Project Name: ALVARADO GARDENS UNIT 2

**CITY OF ALBUQUERQUE
PLANNING DEPARTMENT
March 30, 2005
DRB Comments**

PROJECT # 1003615 APPLICATION # 05-00494

RE: Lots 29A & 29B, Alvarado Gardens, Unit 1/minor plat

PLAT OF
 TRACT 29-A-1 & TRACT 29-B-1
 ALVARADO GARDENS, UNIT 2
 TOWN OF ATRISCO GRANT
 PROJECTED SECTION 1, T. 10 N., R. 2 E., N.M.P.M.
 CITY OF ALBUQUERQUE
 BERNALILLO COUNTY, NEW MEXICO
 JANUARY 2005
 SHEET 2 OF 2

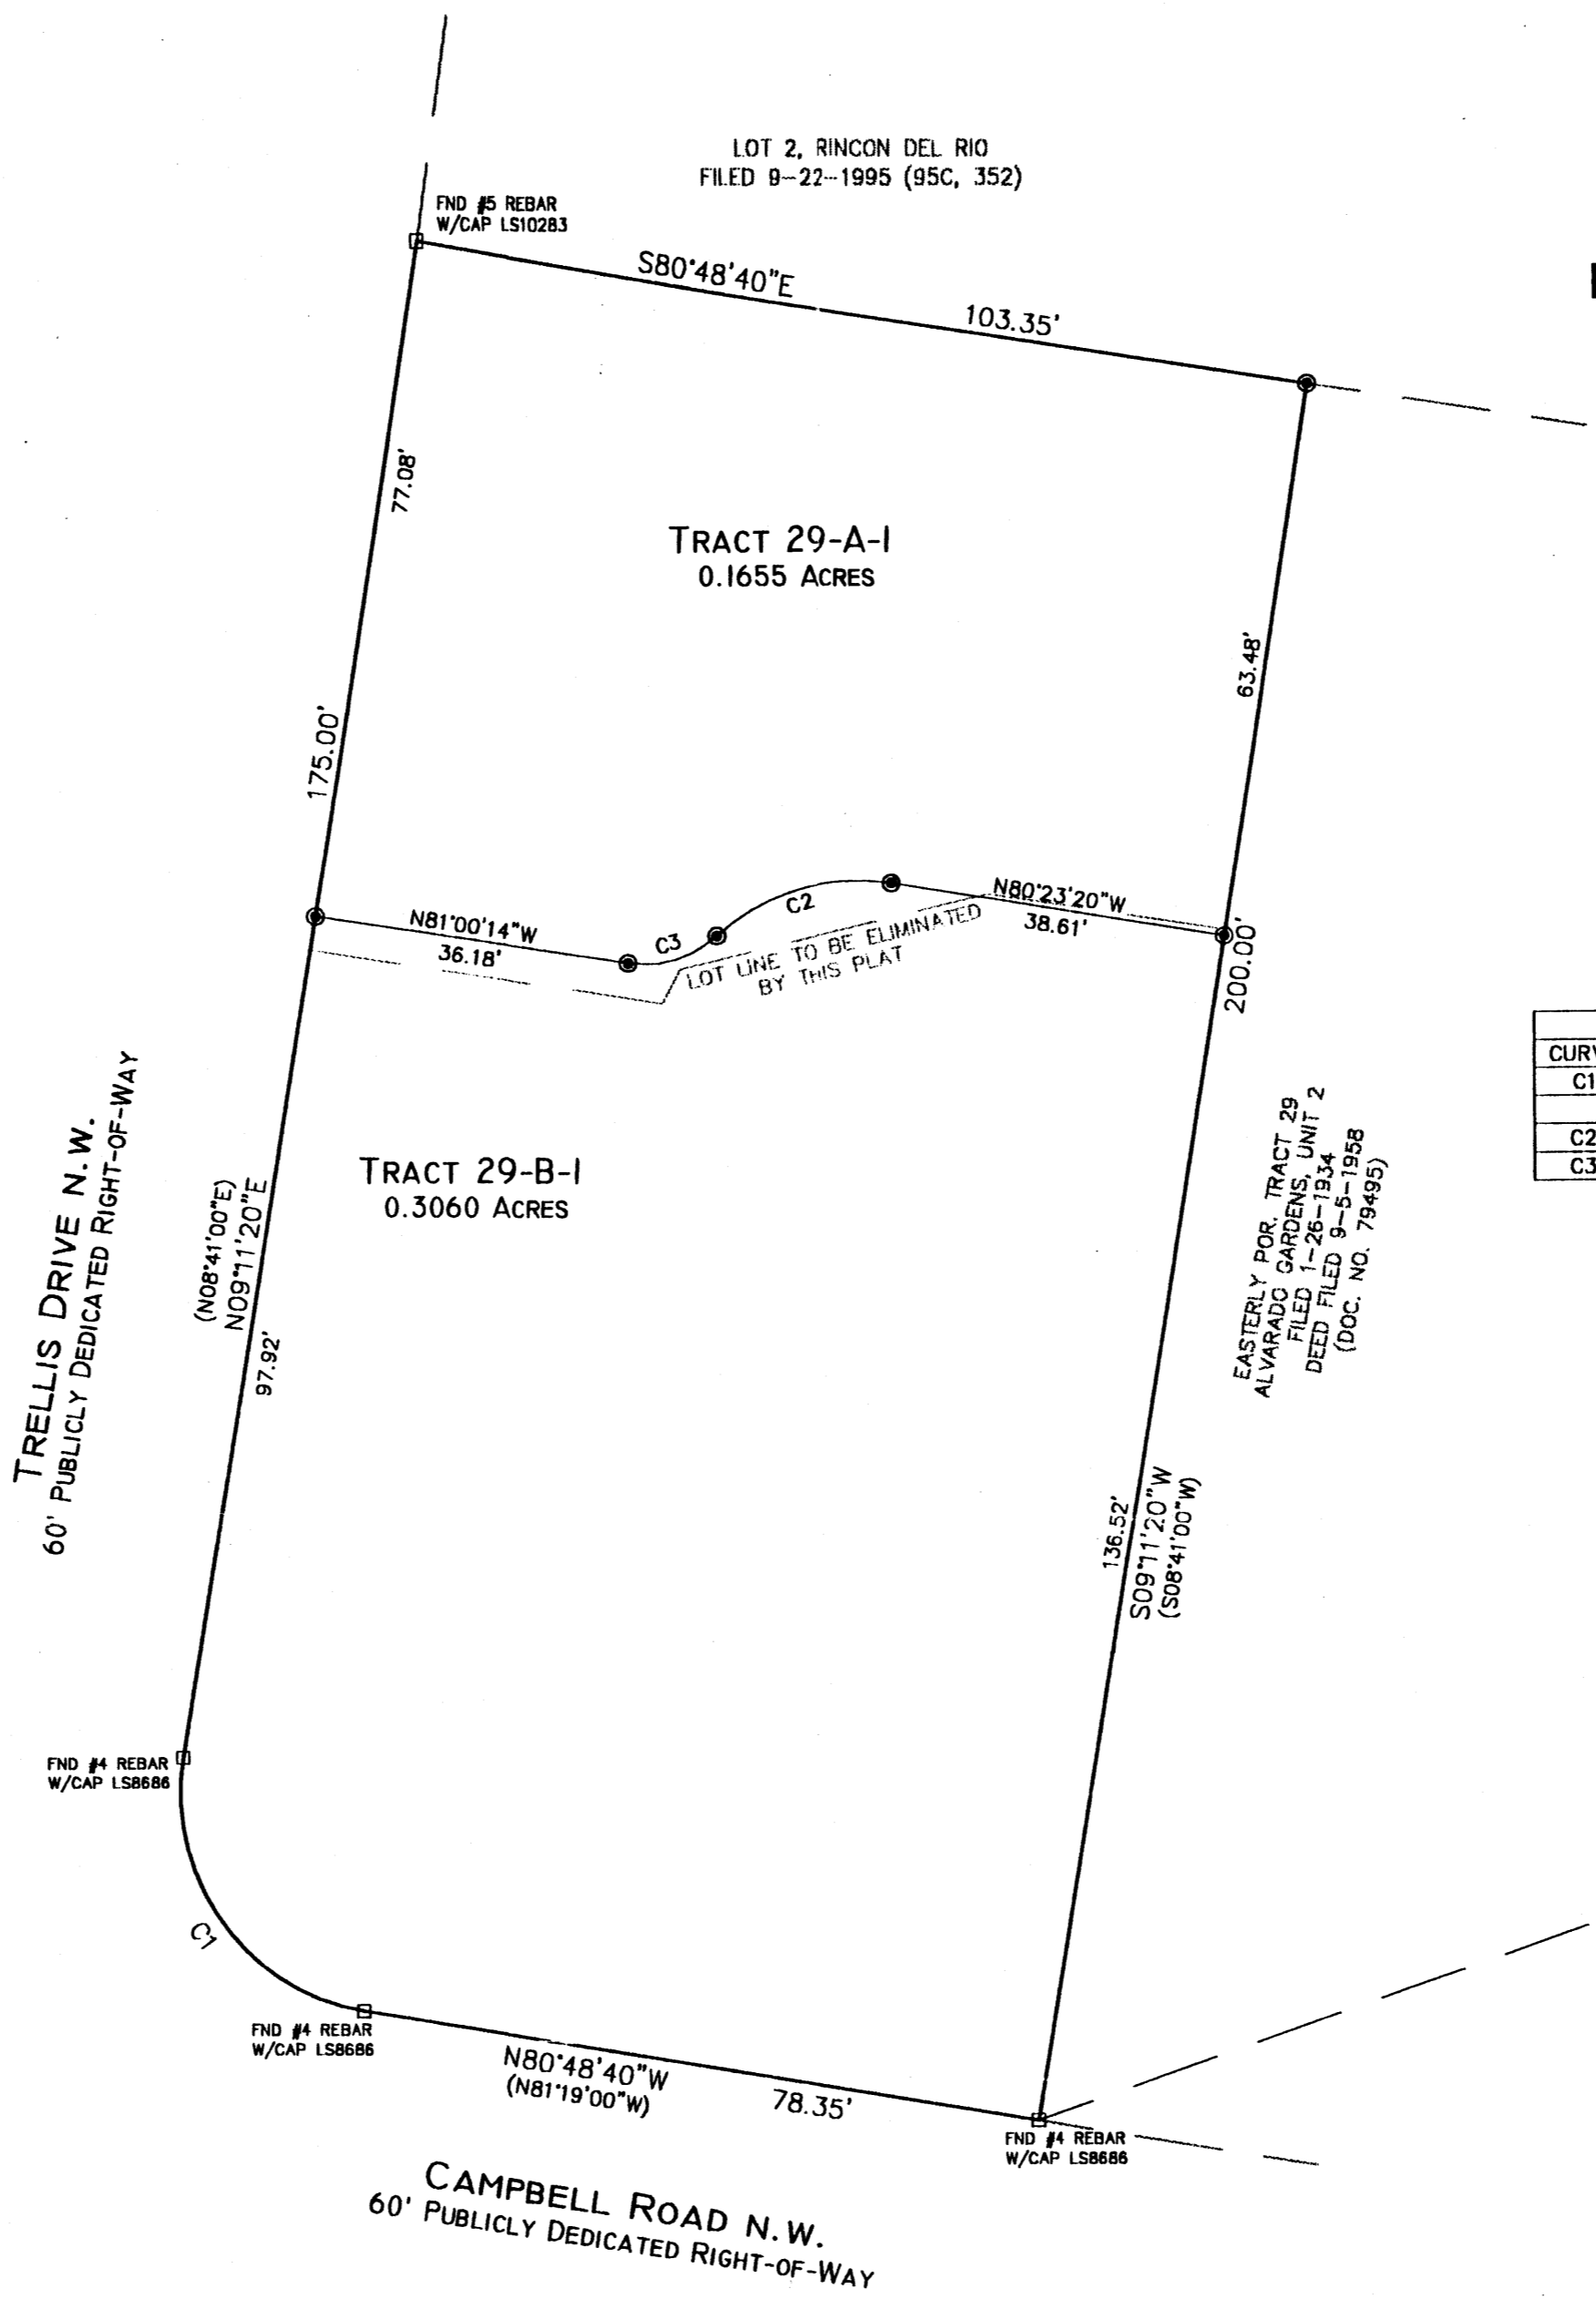
Tract 29A, as it exists today, is nonconforming to the lot size requirements for RA2 zoning. The proposed replat would decrease the size of this parcel even further.

RA2 zoning requires a minimum of 10,890 square feet. In addition, the minimum lot width is 75 feet measured 50' back from the property line. This proposed replat would make Tract 29A nonconforming. It appears the lot conforms to this requirement as it exists today.

Planning cannot approve the proposed replat as shown unless variances are granted.

An application for variances to the minimum lot size requirements for RA2 zoning is possible.

Planning will withhold signing the plat upon either approval or denial of these variance requests should applicant desire to pursue this option.
